Application No: K/16/21/HH
Site Address: Sea Lodge 7 Coastal Road Kingston BN16 1SJ
Description of works: Internal alterations to existing dwelling. Demolition and replacement of existing rear extension with new single storey extension and first floor terrace above with external staircase. Replacement of main roof and 4no. new dormers with windows. Replacement roof tiles to single-storey projections on North elevation. Proposed rear single storey minor extension to garage to form entrance lobby. Alterations to external facade of house and replacement windows and doors throughout. Associated landscaping to suit.

Thank you for your internet representation made on 16th June 2021 which has been recorded as an objection with the comments as follows:

Project Coastal Road Drawing Proposed Second Floor	Project No. 2107 Dwg No. 3.102 Scale 1:100 @ A3	Rev Date Notes </
--	---	--

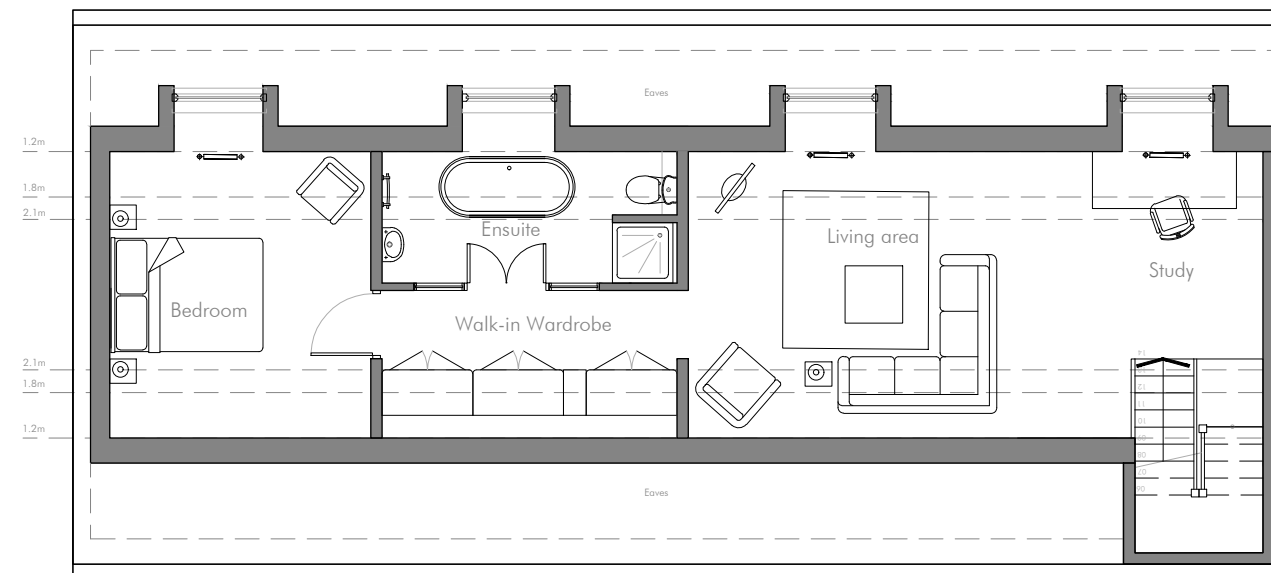
the additional one metre plus in height of the roofline and new bedrooms:

It will cause significant shadowing to my main first floor and ground floor terraces (which have seating and dining provision) as well as pose a clear invasion of privacy to both areas.

Both are used extensively and are currently not overlooked .
